Subject: FP/212/20/OUT 6 THE LOOP

Please accept this email as an objection to the planning application which has been submitted for the above address.

Title
Block and Location Plans

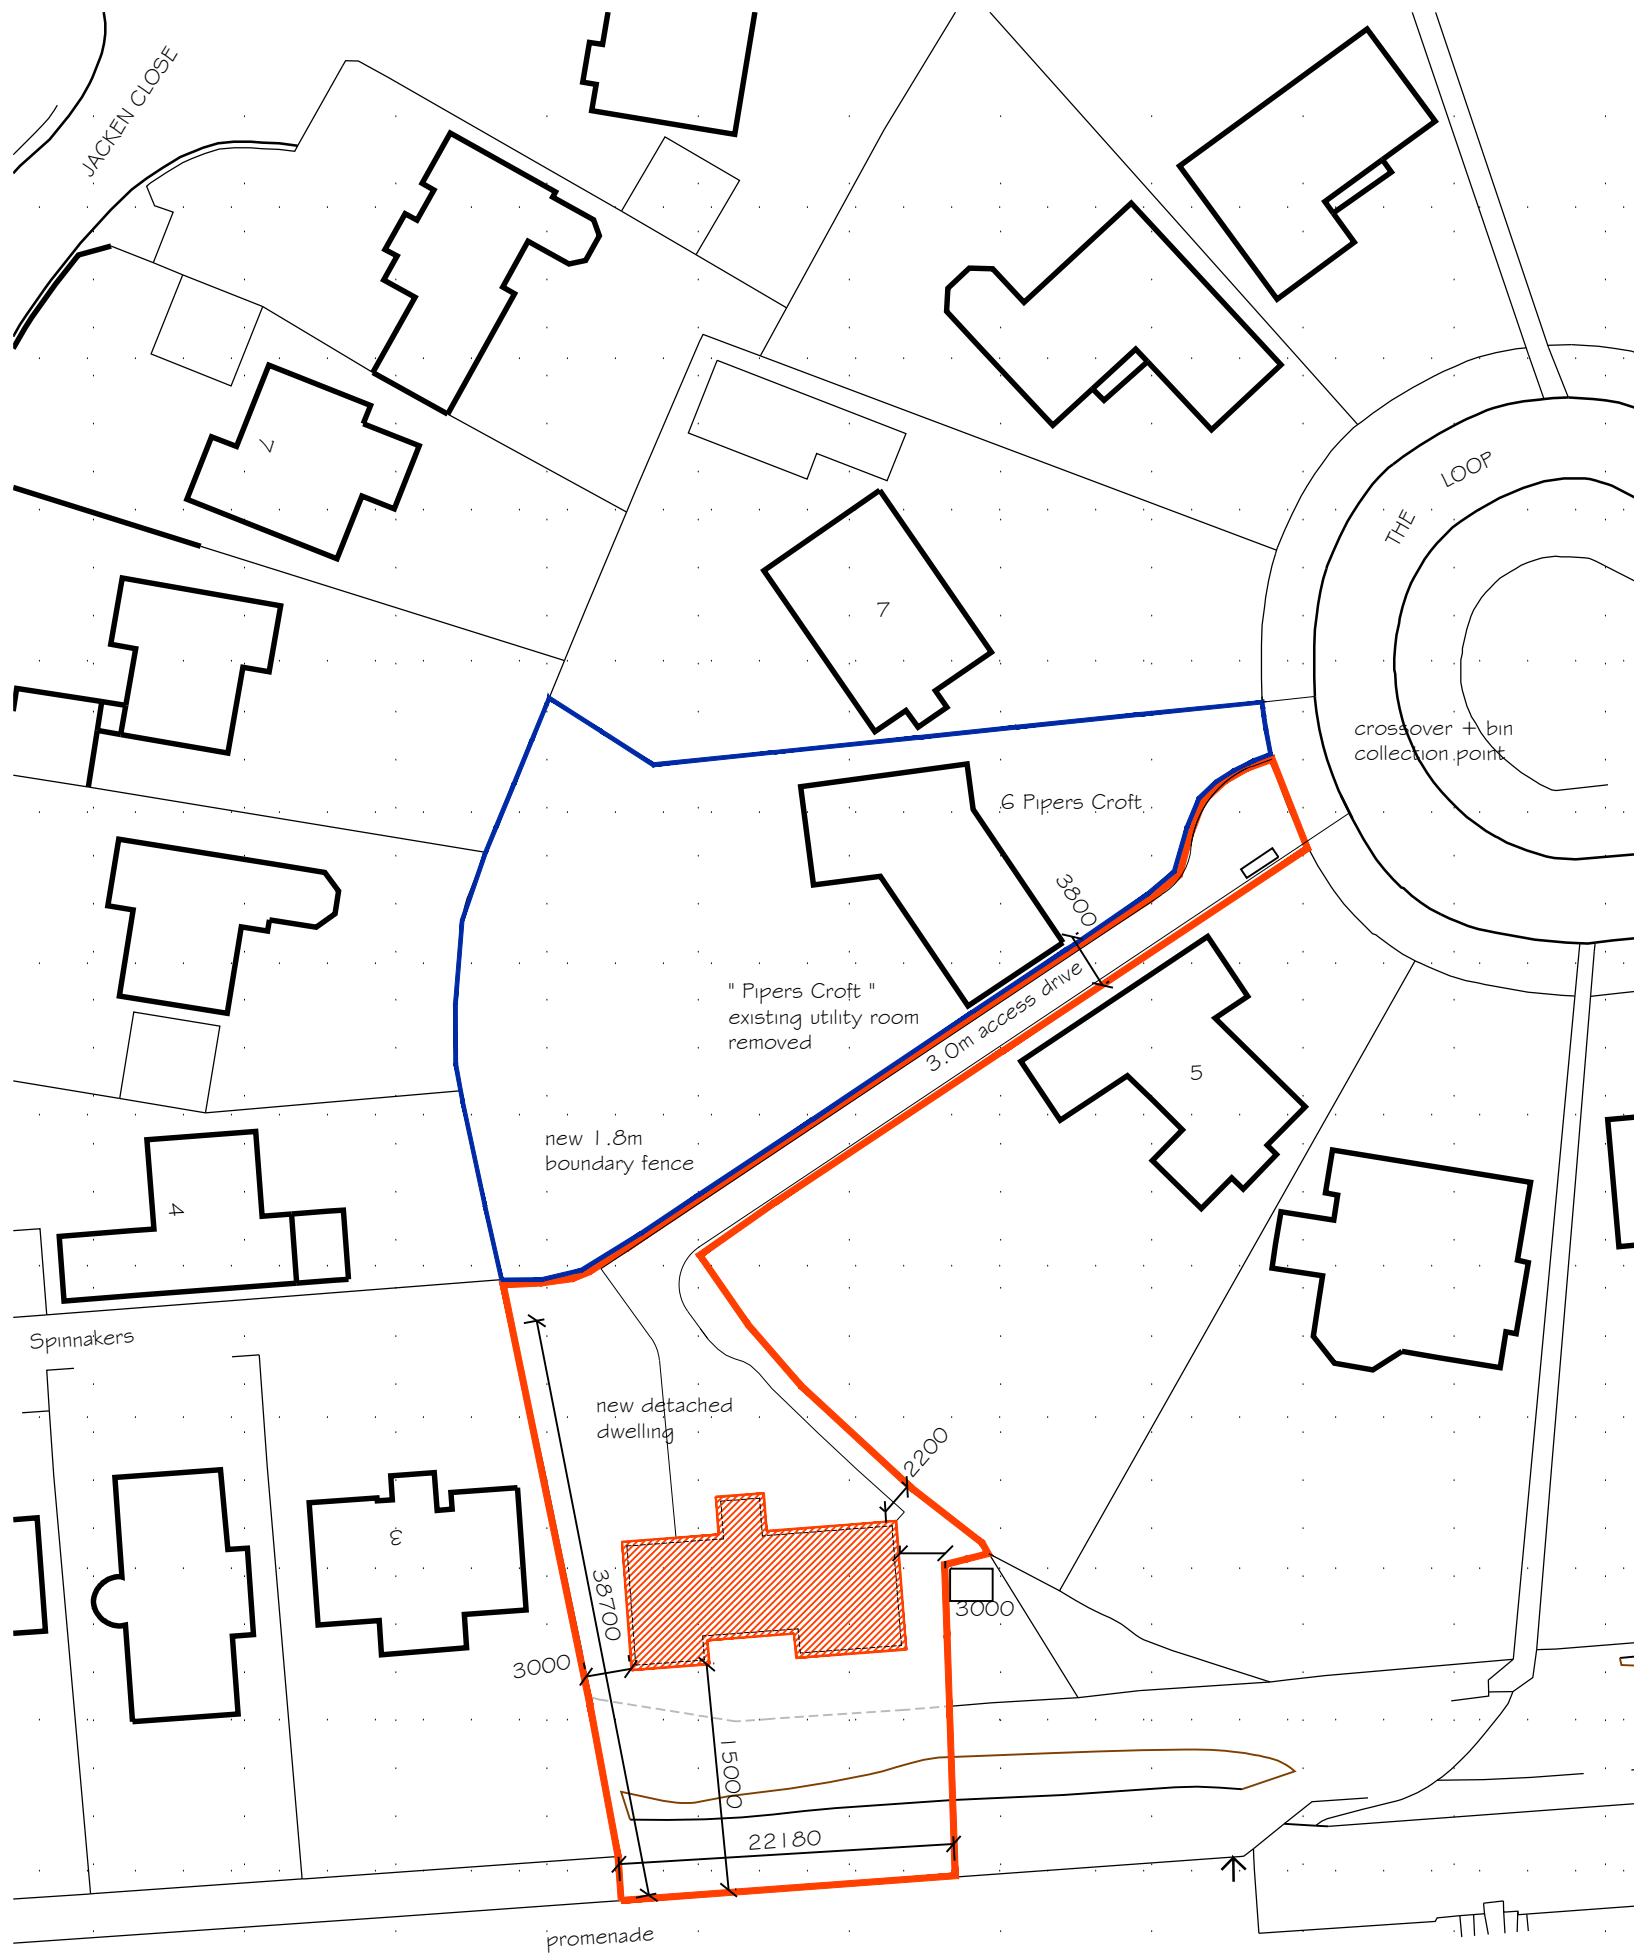
There is highlighted in green stripes a water storage drain across the front of the proposed property which is the subject of at least annual maintenance, and is there for the backup storage of surface water.

Directly where the new house is proposed to be sited, there is a large dry ditch which is there for overflow purposes when surface run off comes down from outside the estate, both of these can be seen in the applicants photographs. No 3 and No4 on ADC planning portal.

This proposed development will further strain the surface water drainage on the estate, and should be refused.
